Sent: 03 December 2010 11:30
To: Planning
Subject: Comments Added: 58 Daffodil Close, Hatfield

Application Details:
Application ID: S6/2010/2314/FP - MISS J PHILLIPS Application Owner: Welwyn & Hatfield
Borough Council (Development Control Officer)
Applicant: K Bond
Location: 58 Daffodil Close, Hatfield
Deadline Date: 03/12/2010 00:00:00
Description: Proposed loft conversion incorporating four rooflights

FRONT

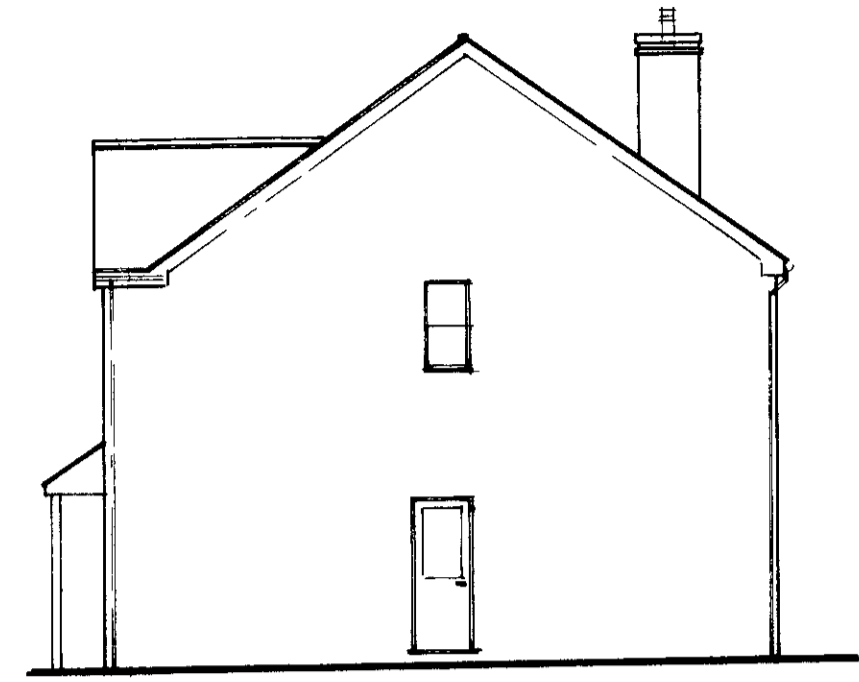
Commented By: [Redacted]
Comment: Hatfield Town Council express concern on the proposed rooflight to the front of the house. An objection would be made if this was the first house in the street to propose a rooflight in the front of the house.
